**TO:** Michael Ducatte  
**PROJECT #:** 23-1390-A  
**PAGE:** 1 of 1  
**DATE:** September 15, 2023  
**LOCATION:** 9250 NC 42, Holly Springs  
**PLAN REF:** 9250 NC 42, Holly Springs  
Project# 23-1390

**THE FOLLOWING CHANGE(S) OR PROPOSED CHANGE(S) LISTED BELOW ARE DEVIATIONS OR CLARIFICATIONS FOR THE ABOVE REFERENCED PLANS:**

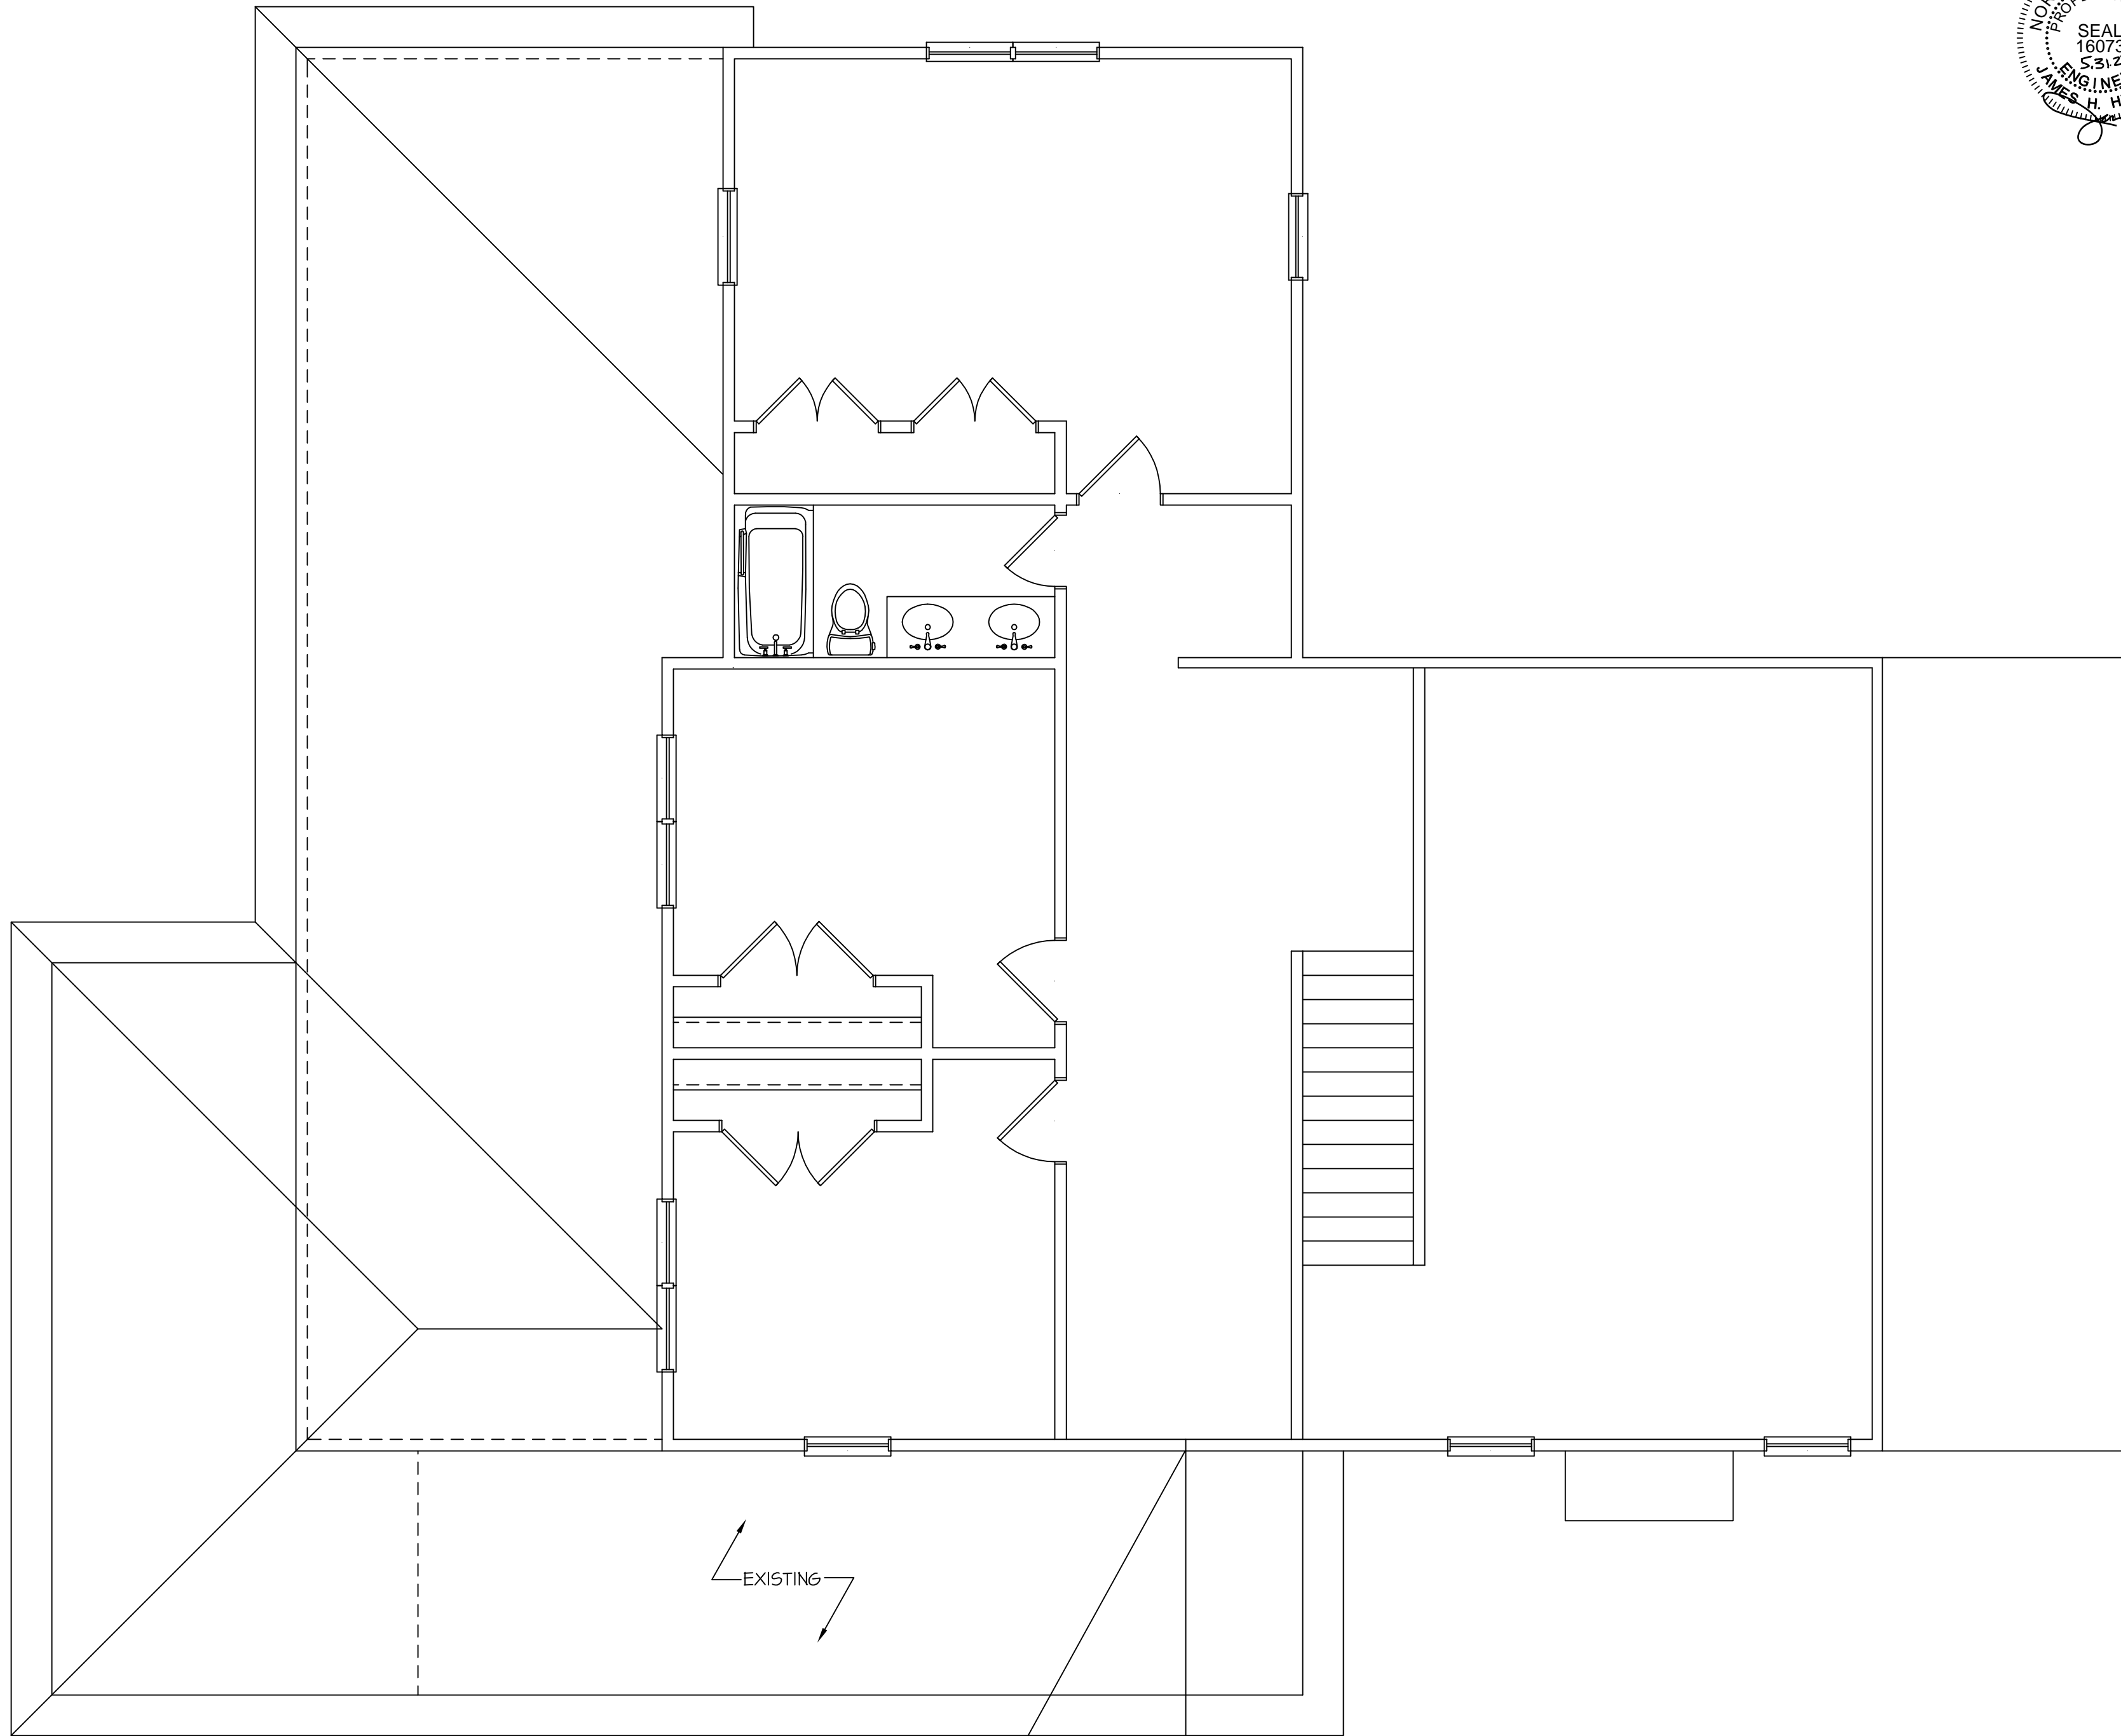
2. Porch Notes: The S-2 page on the set of Structural plans shows porch posts labeled as "4x4 treated post (or equal), see Porch Post Notes". Please be advised that the connectors listed in the "Porch Post Notes" are recommended connectors only. Alternative connectors that meet the NC Residential Code, any local codes, and/or the building inspector's interpretation or approval may be substituted.

ROOF STRUCTURAL PLAN

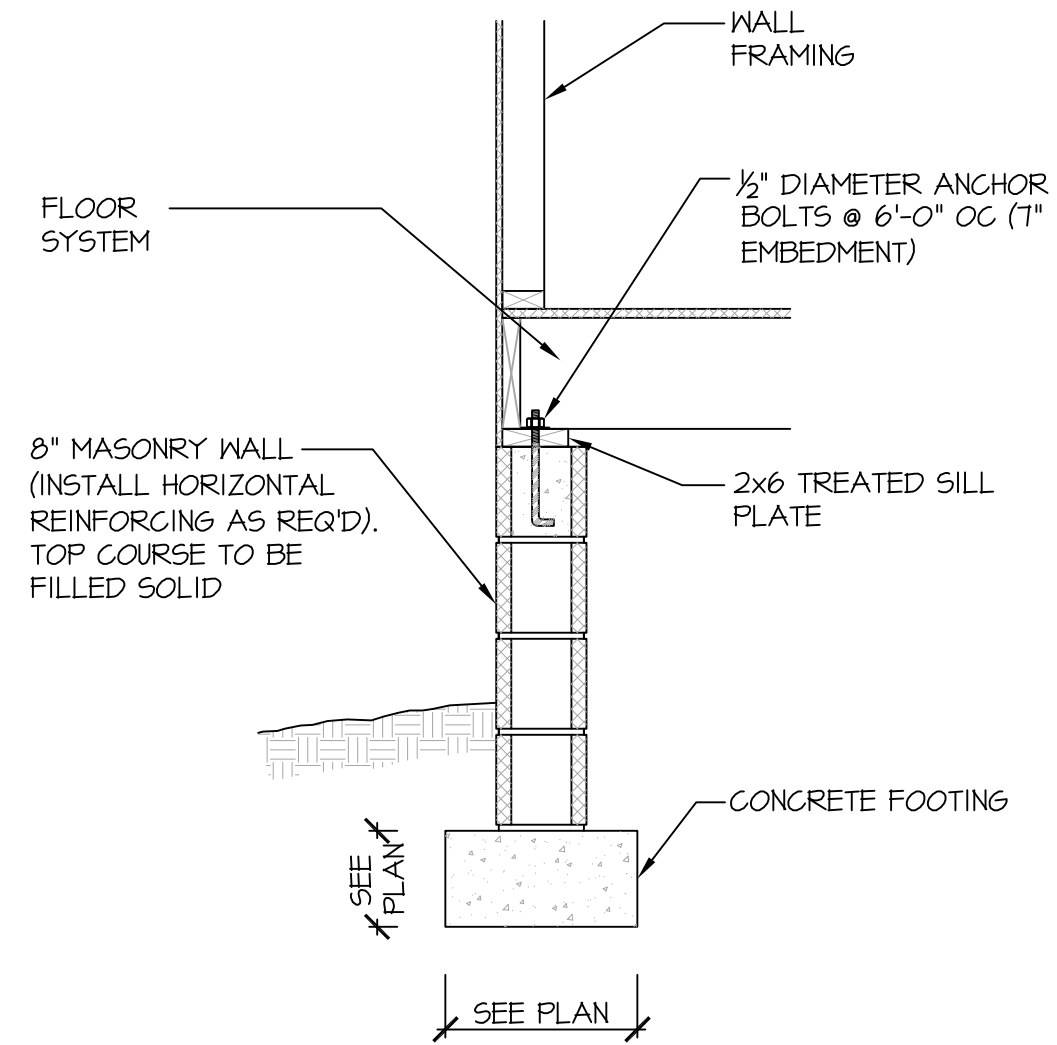
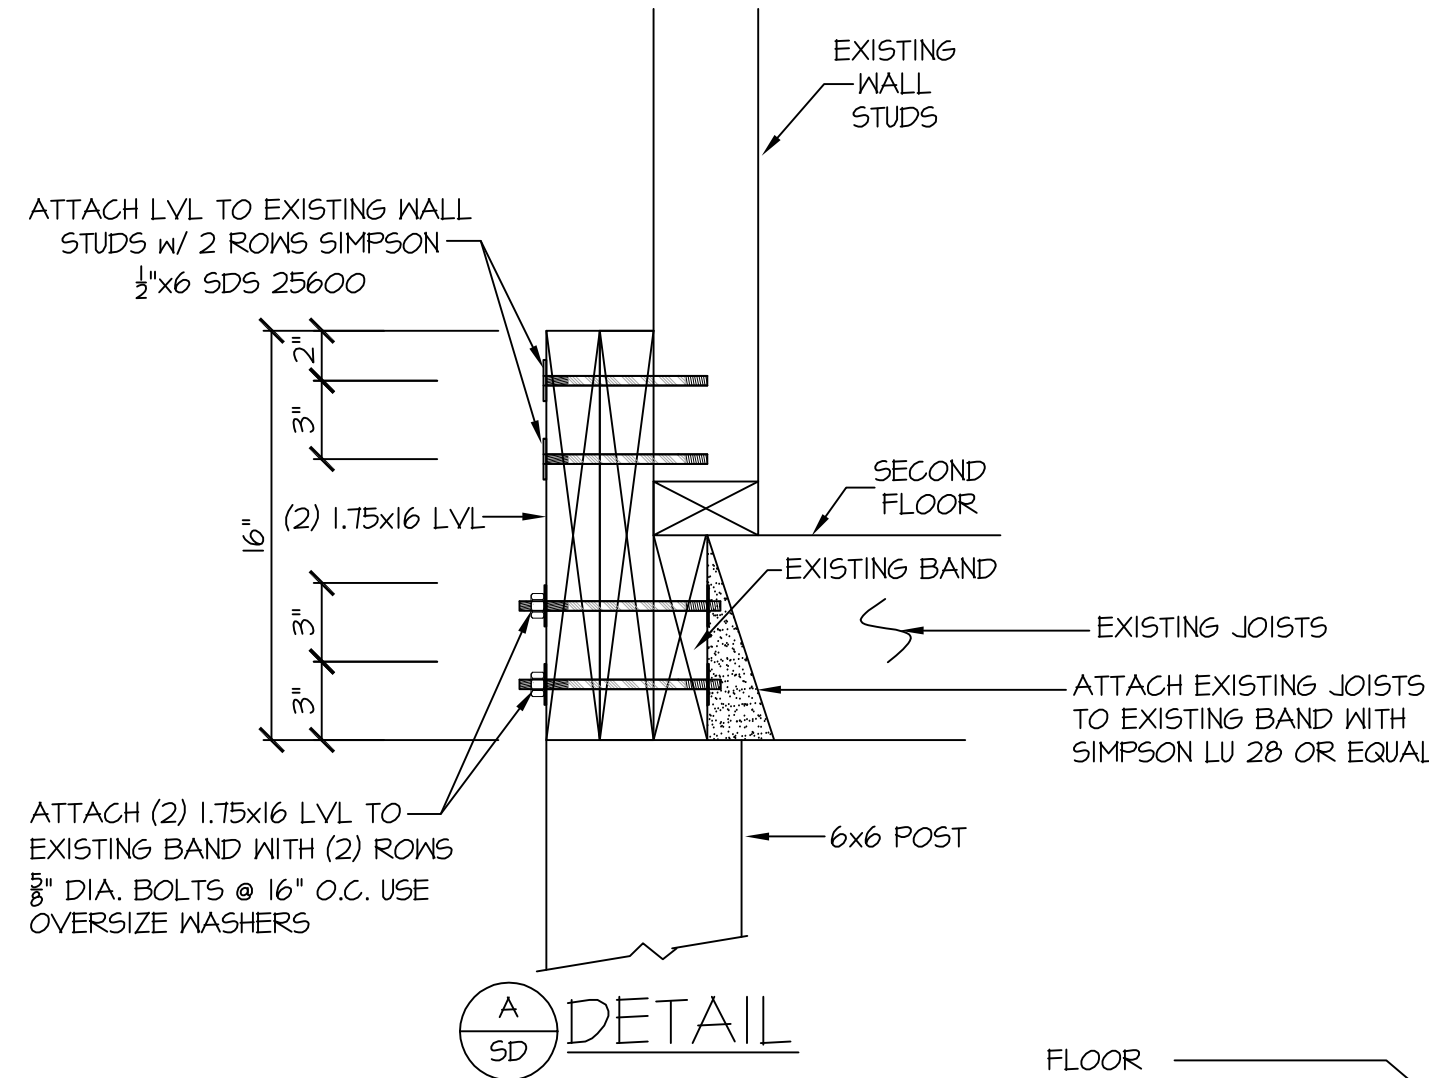
1. Sun Roof Hip: The original plans call for a flat ceiling in the Sun Room. Per information provided by the builder the ceiling is vaulted. The original plans call for a (2) 2 x 10 hip or a (1) 1.75 x 11.875 LVL hip in the Sun Room. Per information provided by the builder a (2) 2 x 10 hip was installed. The (2) 2 x 10 hip is not adequate with the vaulted ceiling.

**Response:** The vaulted ceiling and hip are adequate providing the hip rafters that are connected to the hip are cut back and a (1) 1.75" x 9.25" LVL is installed and attached to both sides of the existing (2) 2 x 10 hip with (3) 10d nails @ 16" O.C. The hip rafters shall then be attached to the new hip. In addition, (2) 3' long CS16 straps shall be wrapped around the corner of the top plates.
